CITY OF ALBUQUERQUE

March 22, 2019

**RE: Aloha RV Expansion
8212 Pan American Fwy NE
Grading and Drainage Plan
Engineer's Stamp Date: 2/26/19
Hydrology File: C18D104**

Based on the submittal received on 2/28/19, the Grading and Drainage Plan cannot be approved until the following are corrected:

ALOHA RV  
8212 PAN AMERICAN FWY, NE  
GRADING PLAN

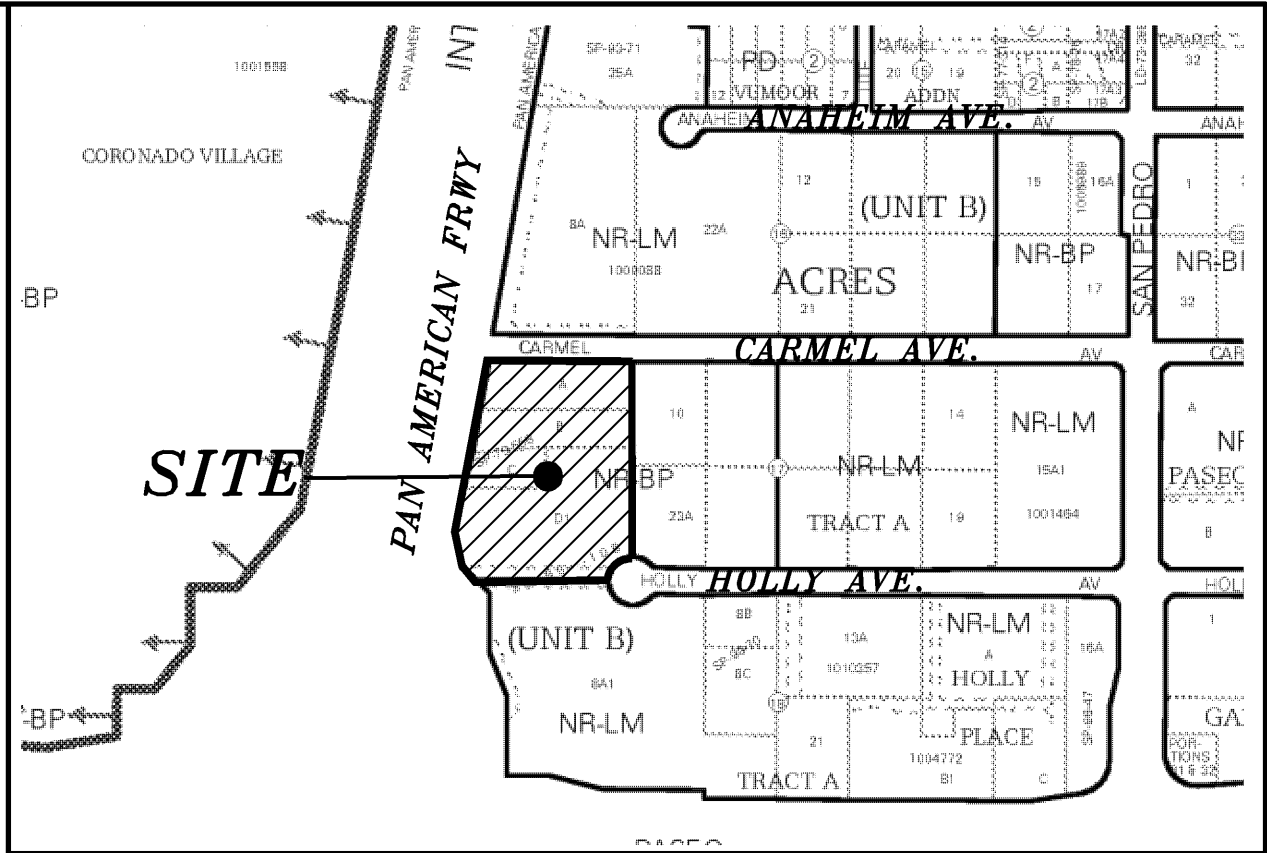
1. The proposed contours seem to ignore the presence of curbs and the 5201' contour near the west drive aisle is incorrect.
2. Provide a defined swale to connect Pond A to Pond B; ensure it does not encroach on the NMDOT ROW and provide a section. The swale will need to be sized for the inflow into Pond A. (Increased discharges or modified discharge points to the NMDOT ROW will require their approval.)
